Appendix D – Detailed Response to Submissions

Table 1 DPHI Request for Information

Table 2 Agency Submissions

Erection of new structures between vault and atrium.

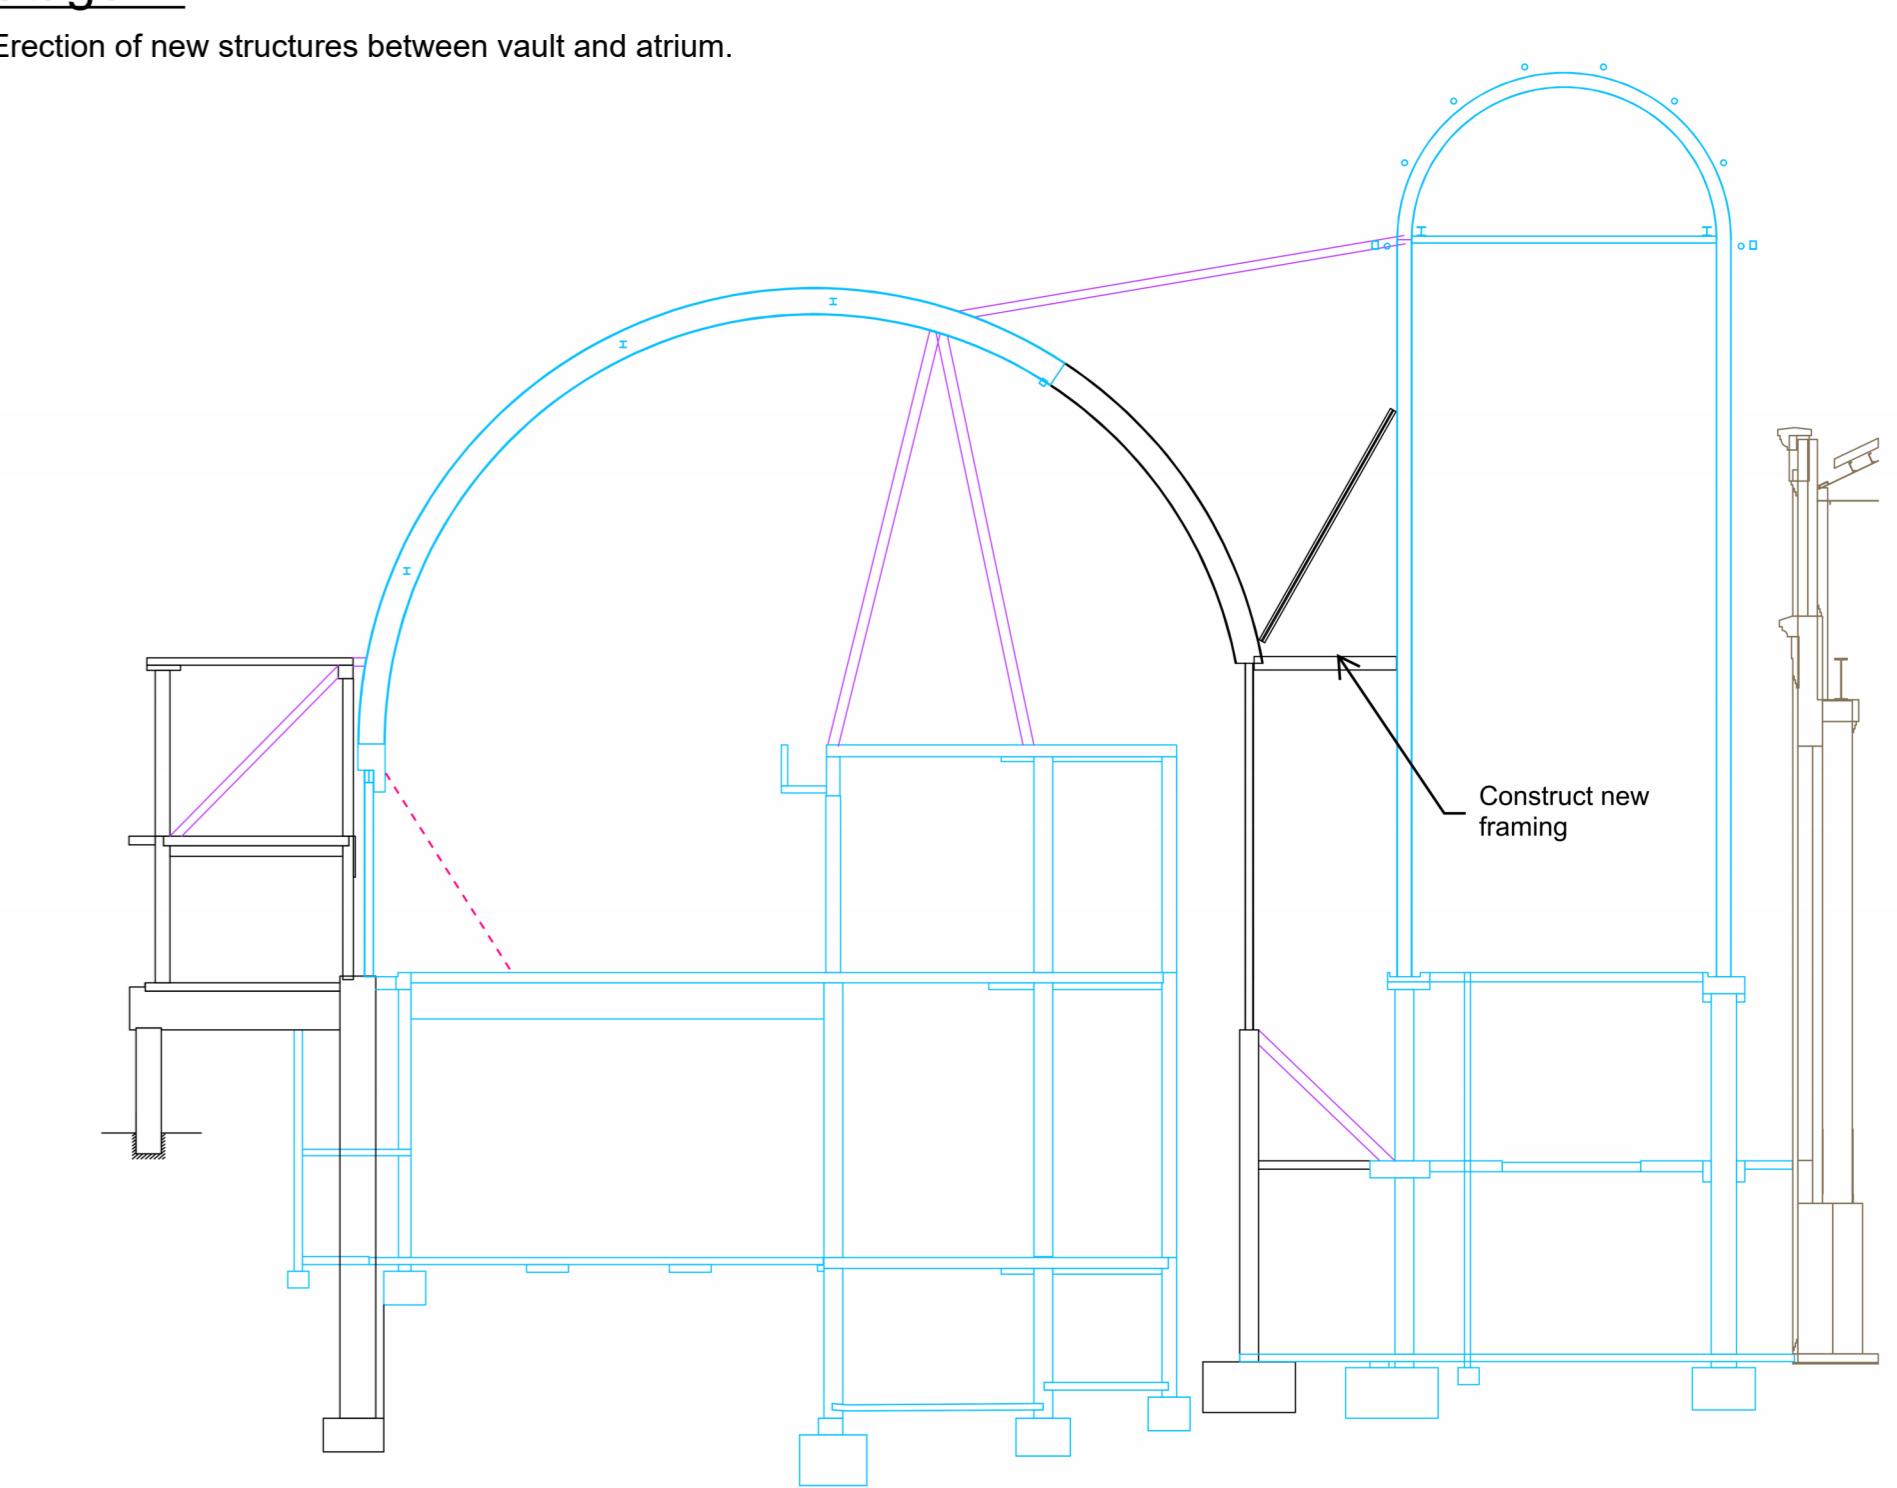
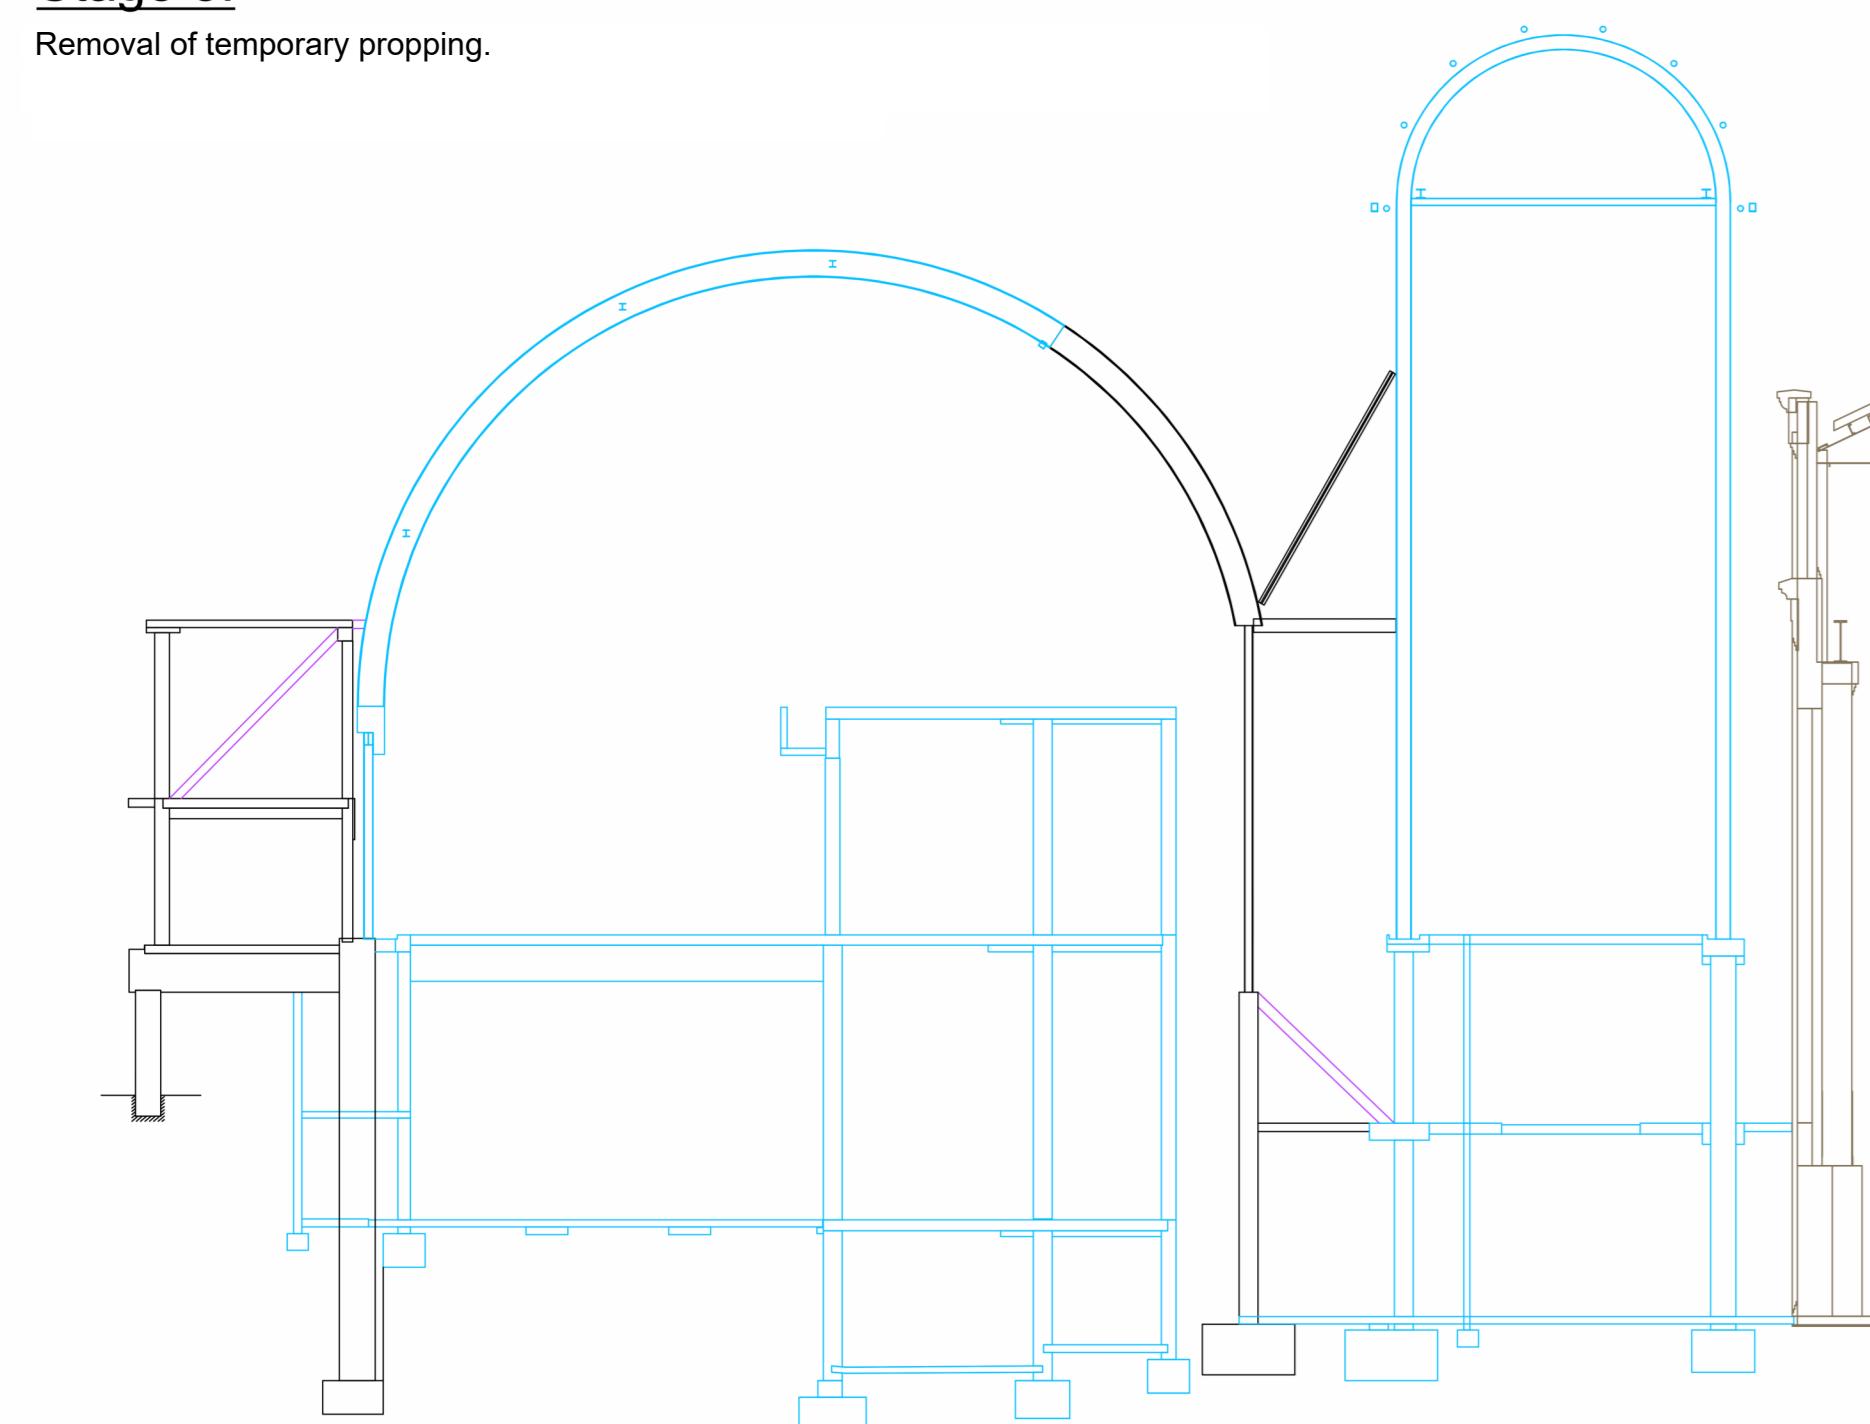
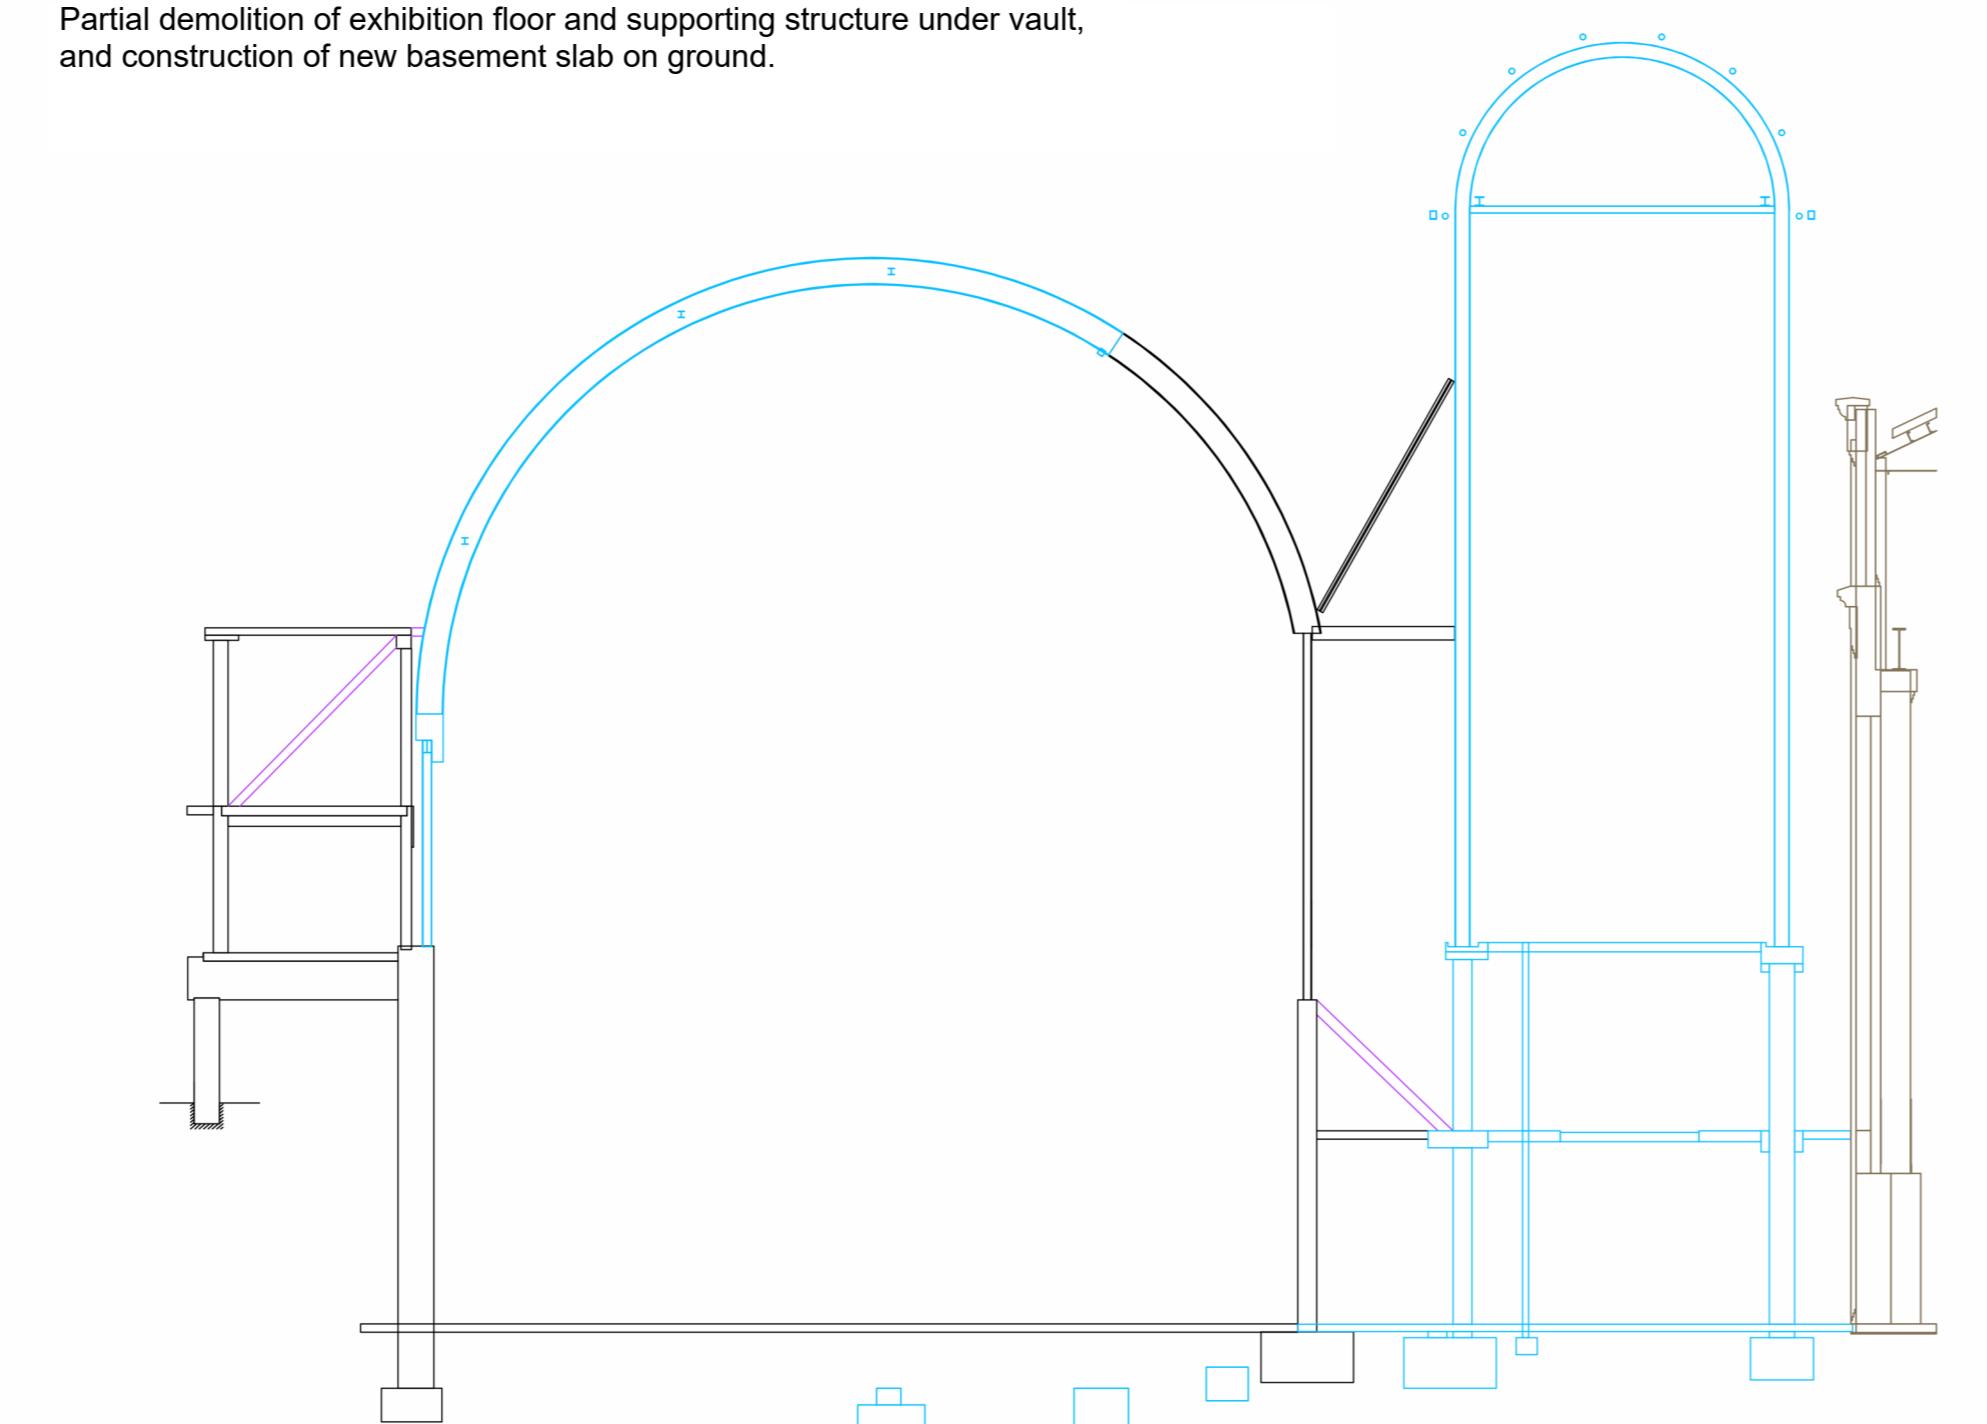
<ul style="list-style-type: none"> - Clarification is required as to whether the intent is to retain the existing roof form and structure and how this would be extended to complete the arch of the barrel. The materiality of the roof is also to be clarified with the continuing use of a high durable long life; lightweight metal roof preferred. Galvanic reactions between dissimilar metals must be avoided or managed. - The demolition of the lower-level colonnade associated with the Wran Hall allows creative industry spaces to be provided along and activate Harris Street. This is supported; however, the spaces would be disconnected from the Powerhouse Museum and servicing and waste removal needs to be further considered. 	<p>finishes. In relation to heritage impact, the amended HIS provides further assessment of these materials.</p> <ul style="list-style-type: none"> • Refer to Amended Design Report at Appendix F. • Servicing of the Creative Industries spaces will need to occur from the Harris Street frontage. The waste servicing requirements for the users of this space will be extremely low and comparable to a typical office use. Emptying of waste would occur on a daily basis by each tenant taking waste to the central waste room within the loading dock. It is expected that each tenancy will be provided with a 10L bin. • Waste reduction initiatives as part of the submitted ESD Report at Appendix BB of the EIS include a commitment to 80% of construction and demolition waste to be recycled by the head contractor.

CoS10	<ul style="list-style-type: none"> • Materials and Building Expression <ul style="list-style-type: none"> - There is only a very limited palette of materials shown on the architectural drawing set - The design report also includes garden mesh and aluminium cladding - The design report also references 'The new built form will be comprised of a mix of recycled and new bricks, brick slips, stone, ceramics, glass, metal cladding and class 2 in situ concrete and precast concrete.' - The proposed materials and finishes need to be further clarified and the drawings should be amended to clarify materials and key these to the elevations and sections. This is also requested to assist in assessing the potential heritage impacts of the additions. - The design of the Wran hall and galleria adaption is generally supported; however, more information is required to understand the amount of demolition and retention of structure. - The northern and southern ends of the Wran hall and the galleria are shown in elevations as brick. More information is required regarding the construction and structural delivery of brick ends to the existing steel super structure. The roof skin is also to be clarified, it is unclear from the renders, what this is intended to be. 	<ul style="list-style-type: none"> • The Amended Design Report at Appendix F to this Submissions and Amendments Report provides further details on the proposed materials and finishes. In relation to heritage impact, the Amended HIS (Appendix L) provides further assessment of these materials. Details regarding the extent of demolition of internal areas within the Wran Building are included within the Structural Sequencing diagrams contained at Appendix H to this Submissions Report.
